APPENDIX A

UTS Central Project
DA Section 96
Response to feedback

University of Technology Sydney

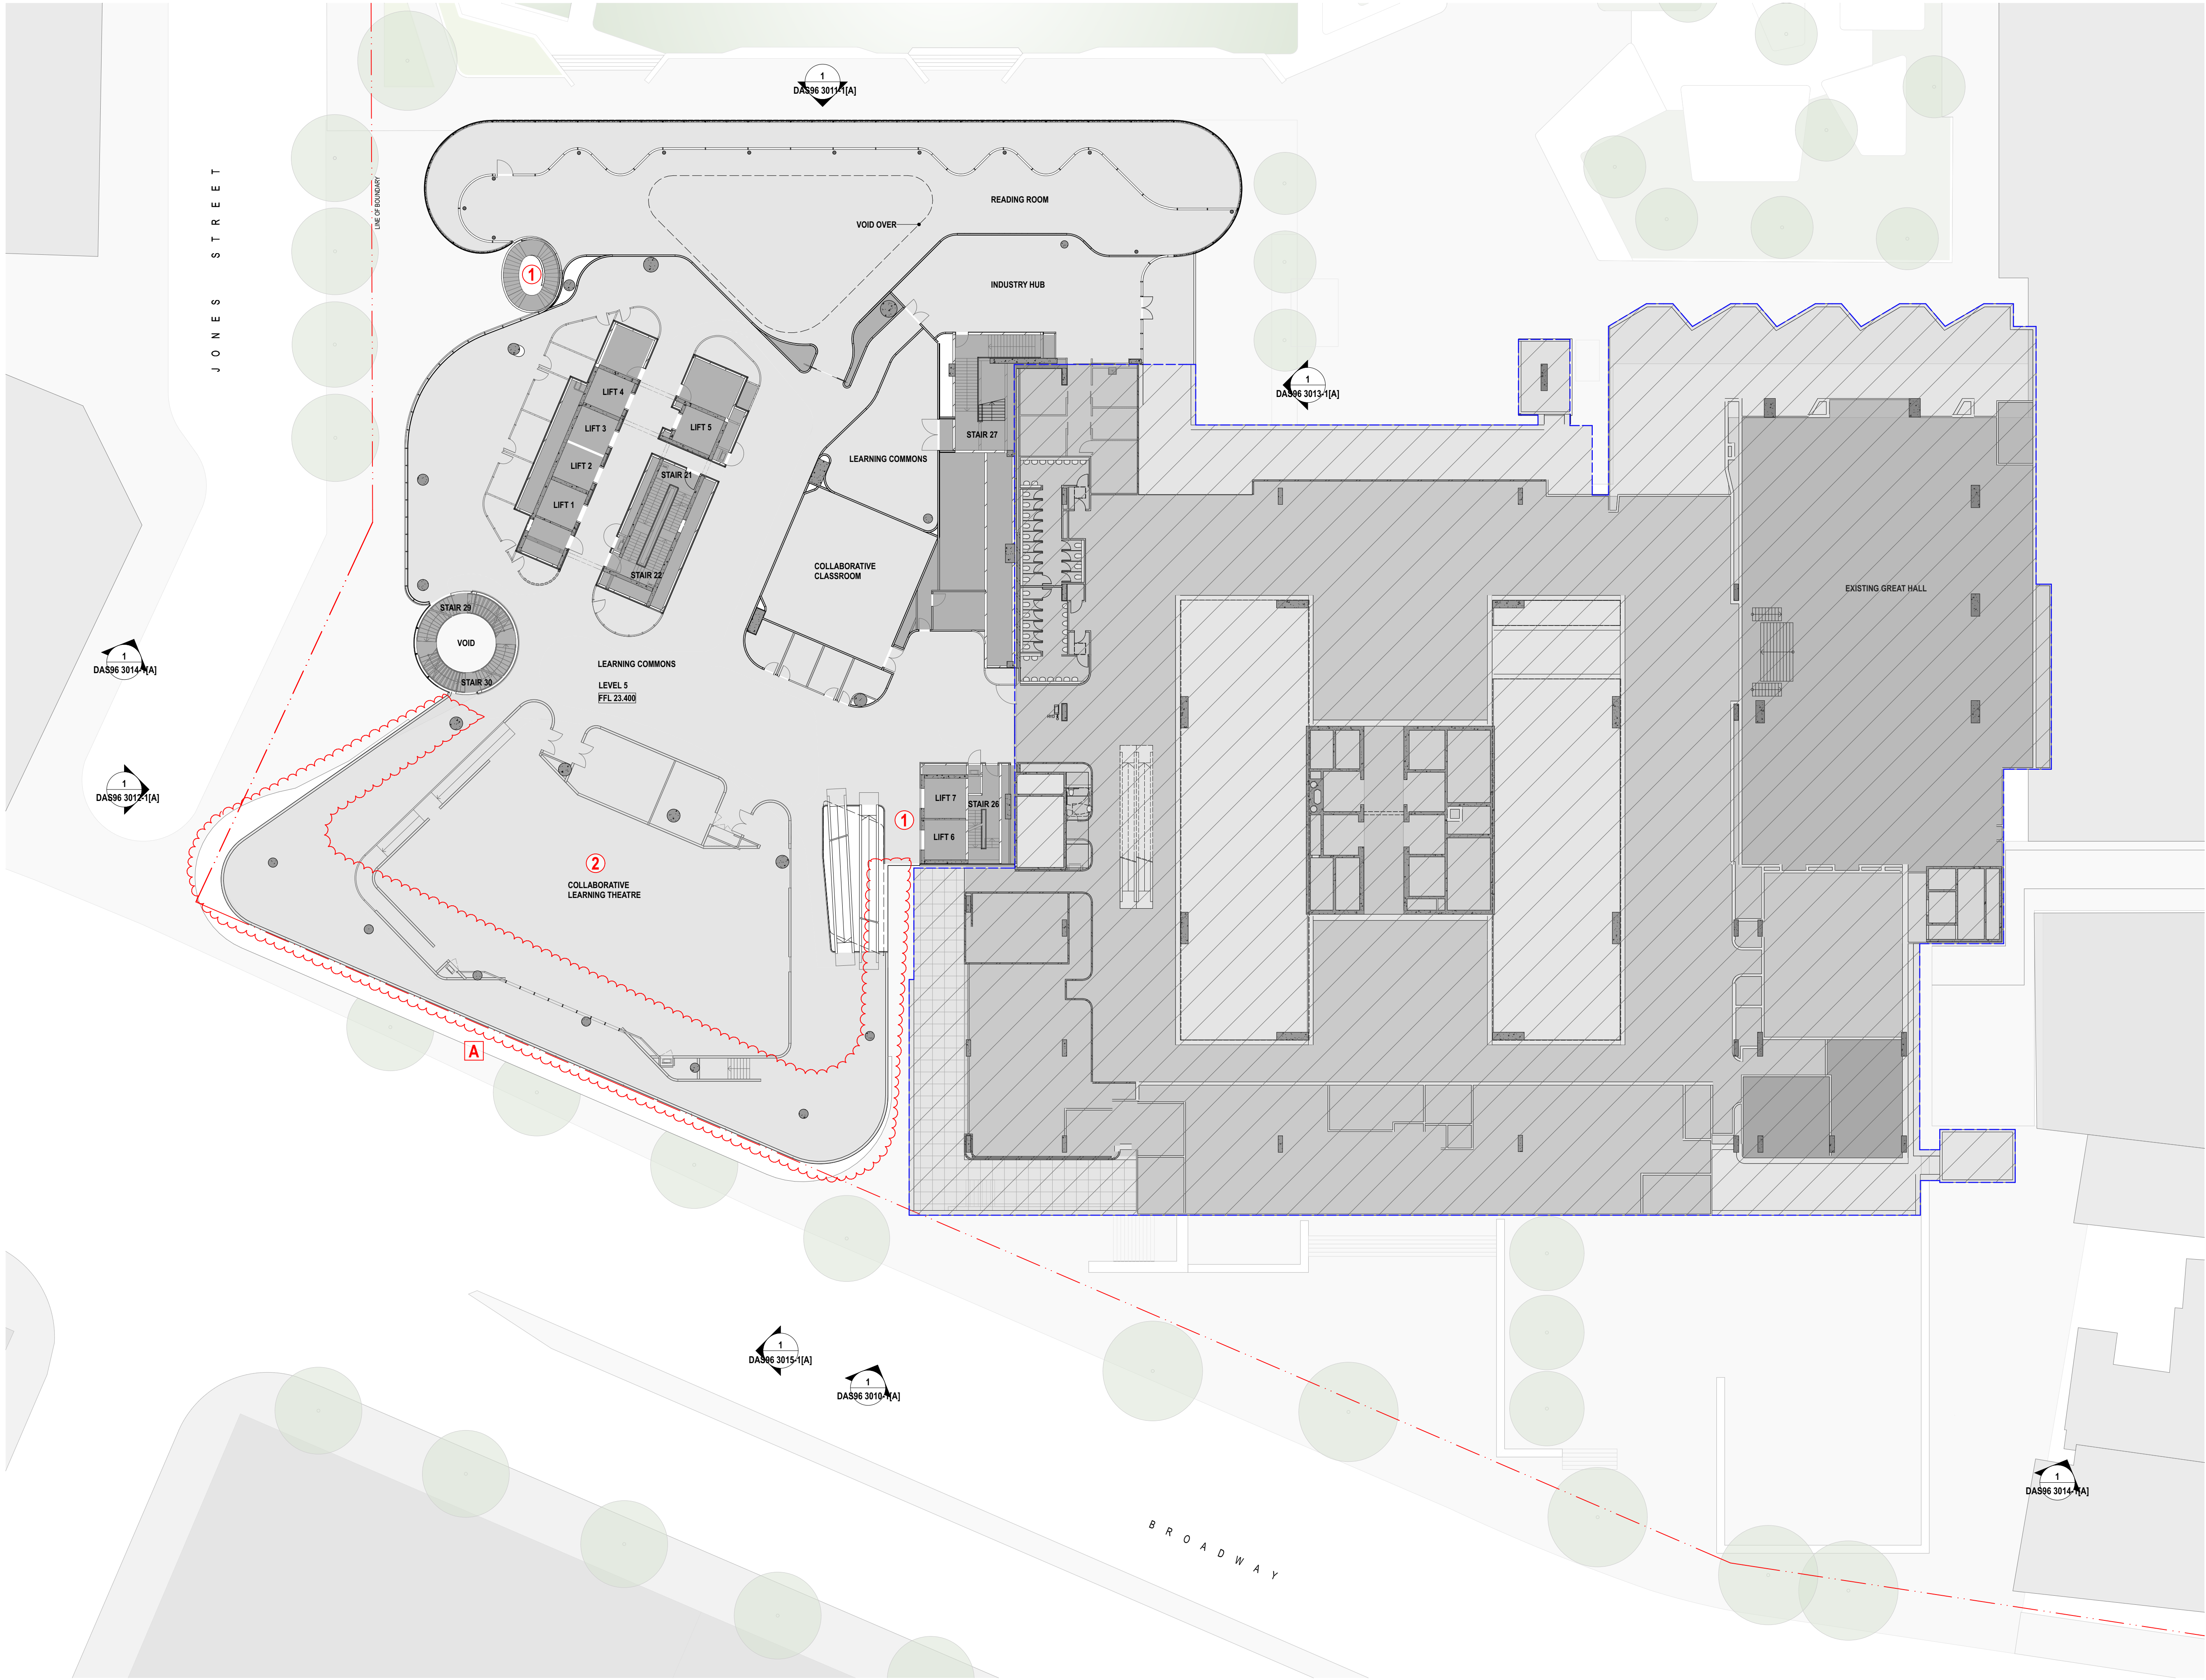
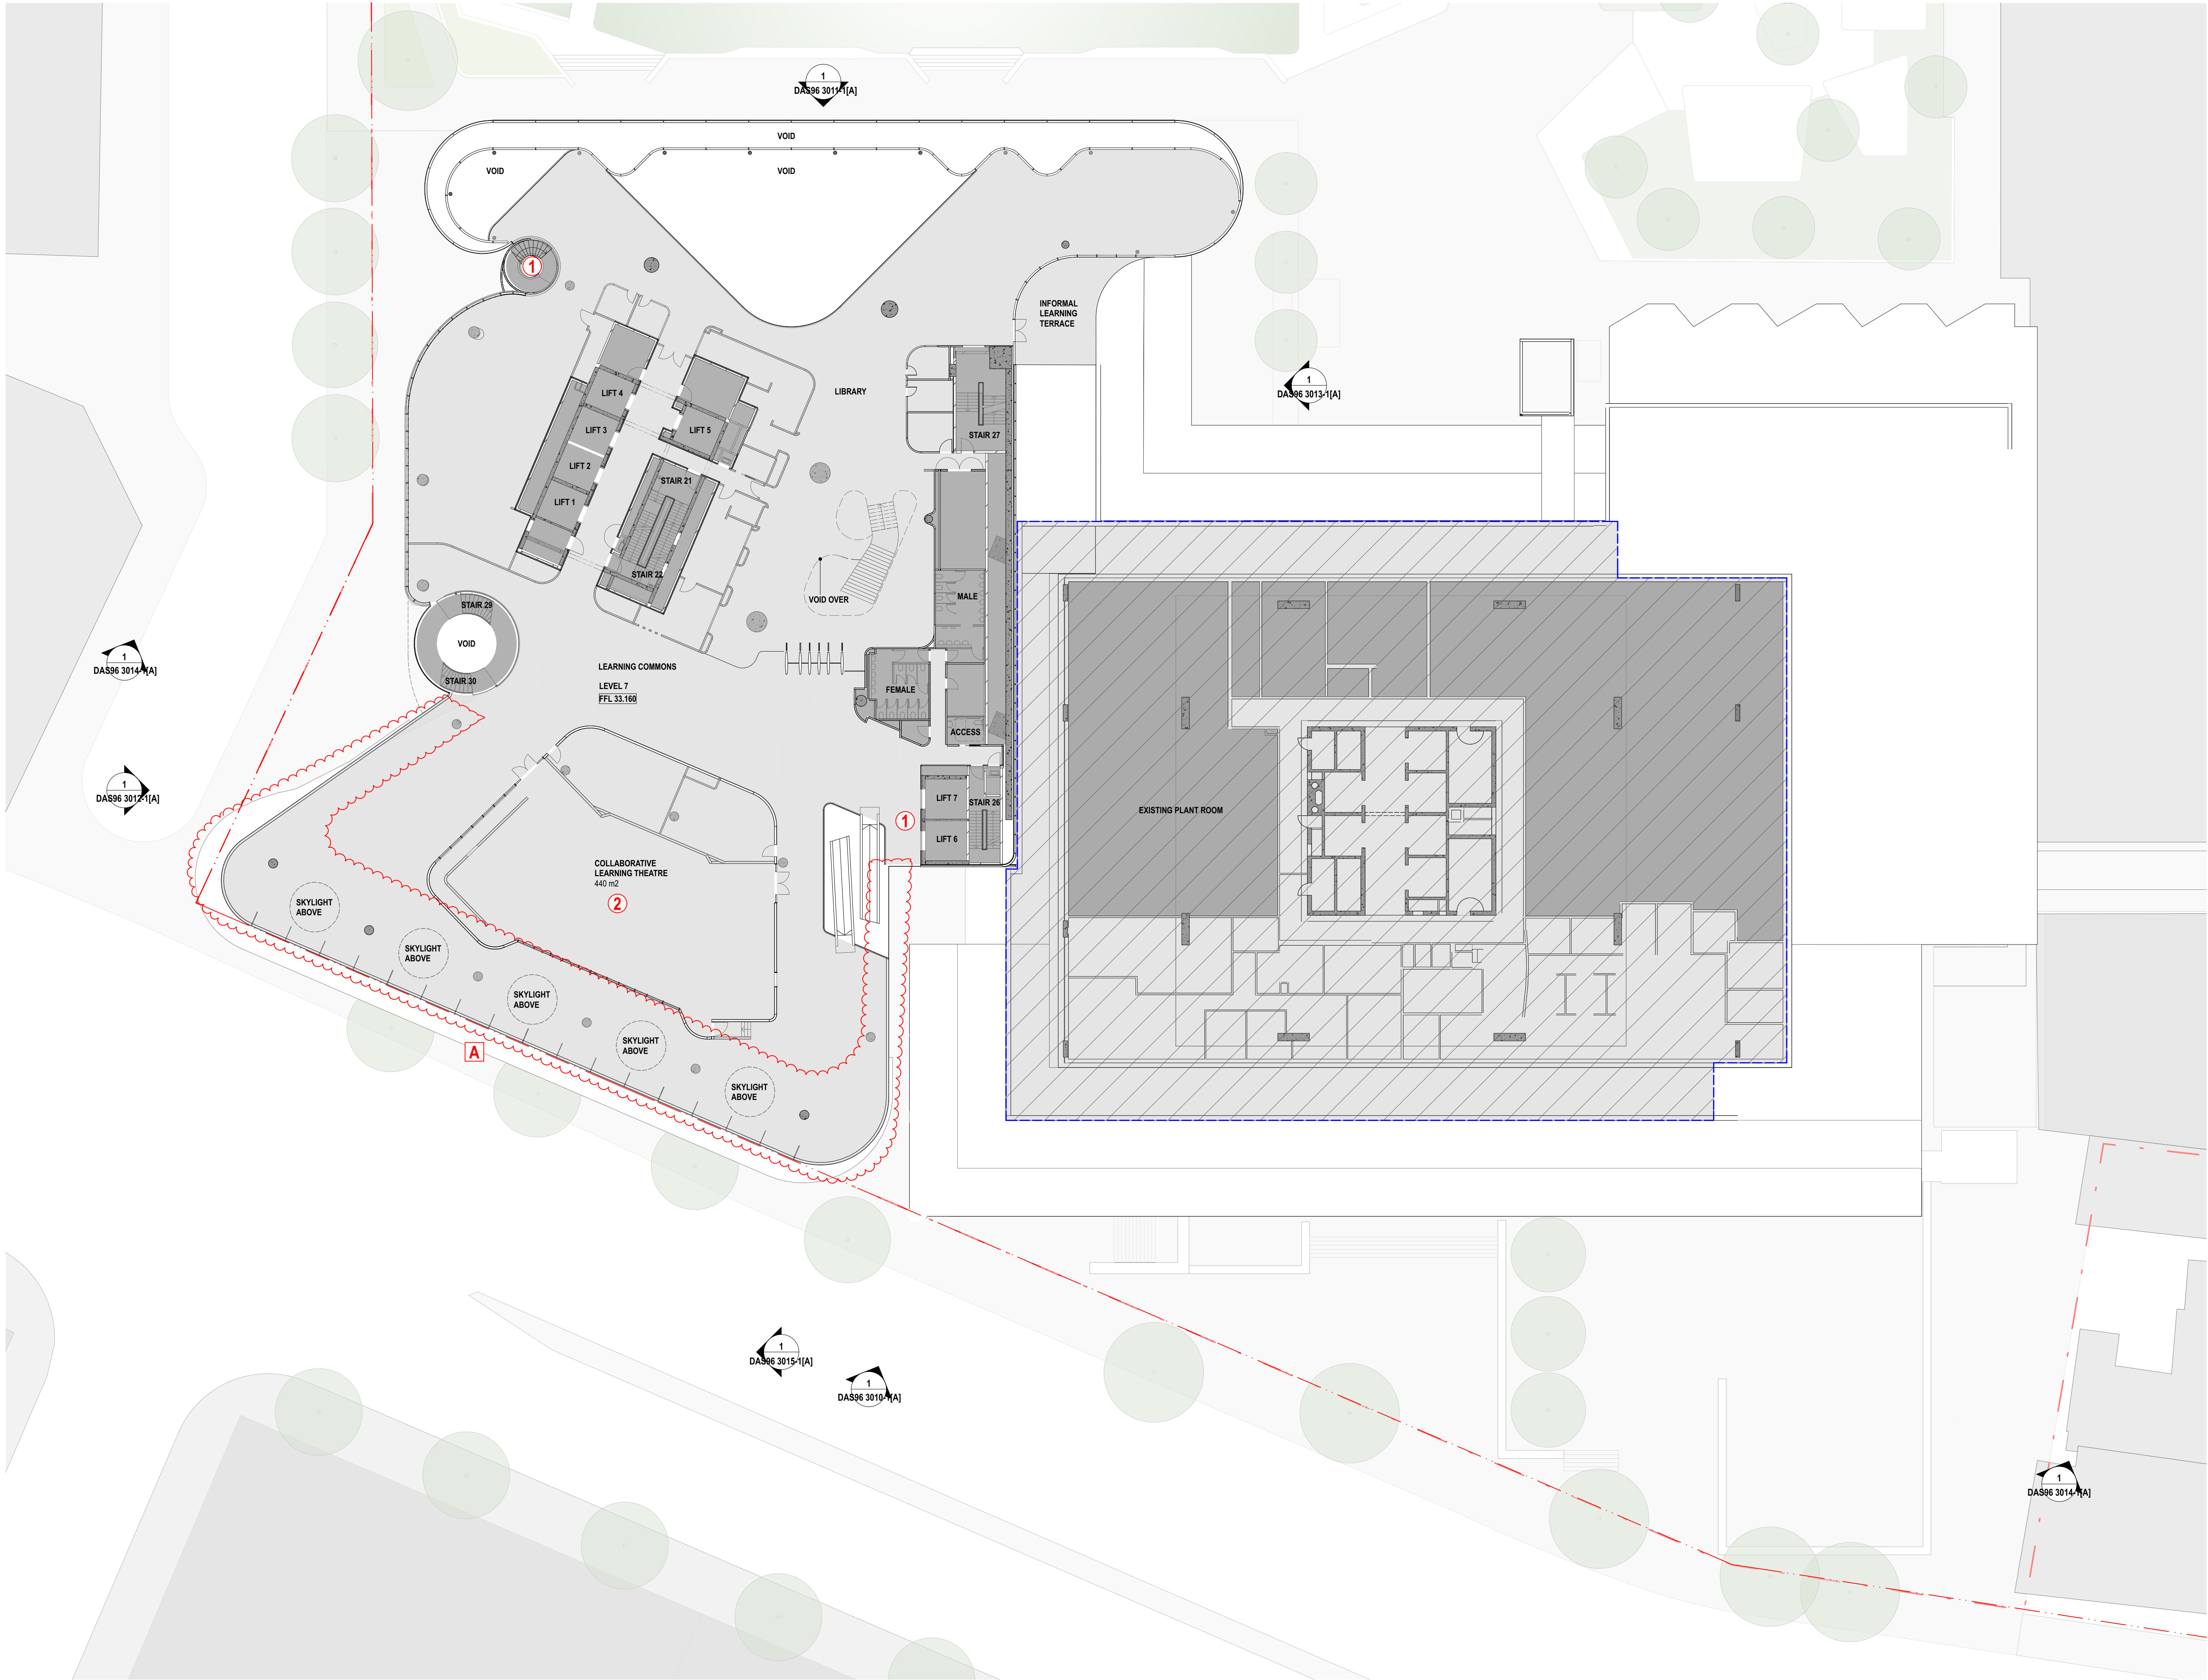
The façade should show a closer relationship to the competition winning entry which includes curvature in the façade in three dimensions.

The Broadway facade has maintained the curvature in the facade in three dimensions and remains consistent with Lacoste + Stevenson's design intent of the original competition winning scheme.

The active edge along the Level 4 Broadway Facade has been maintained where the conditions of the site have allowed. One entrance from the competition (midway between the Jones st corner and the Main entrance) was found to be impractical due to the change in levels across the site.
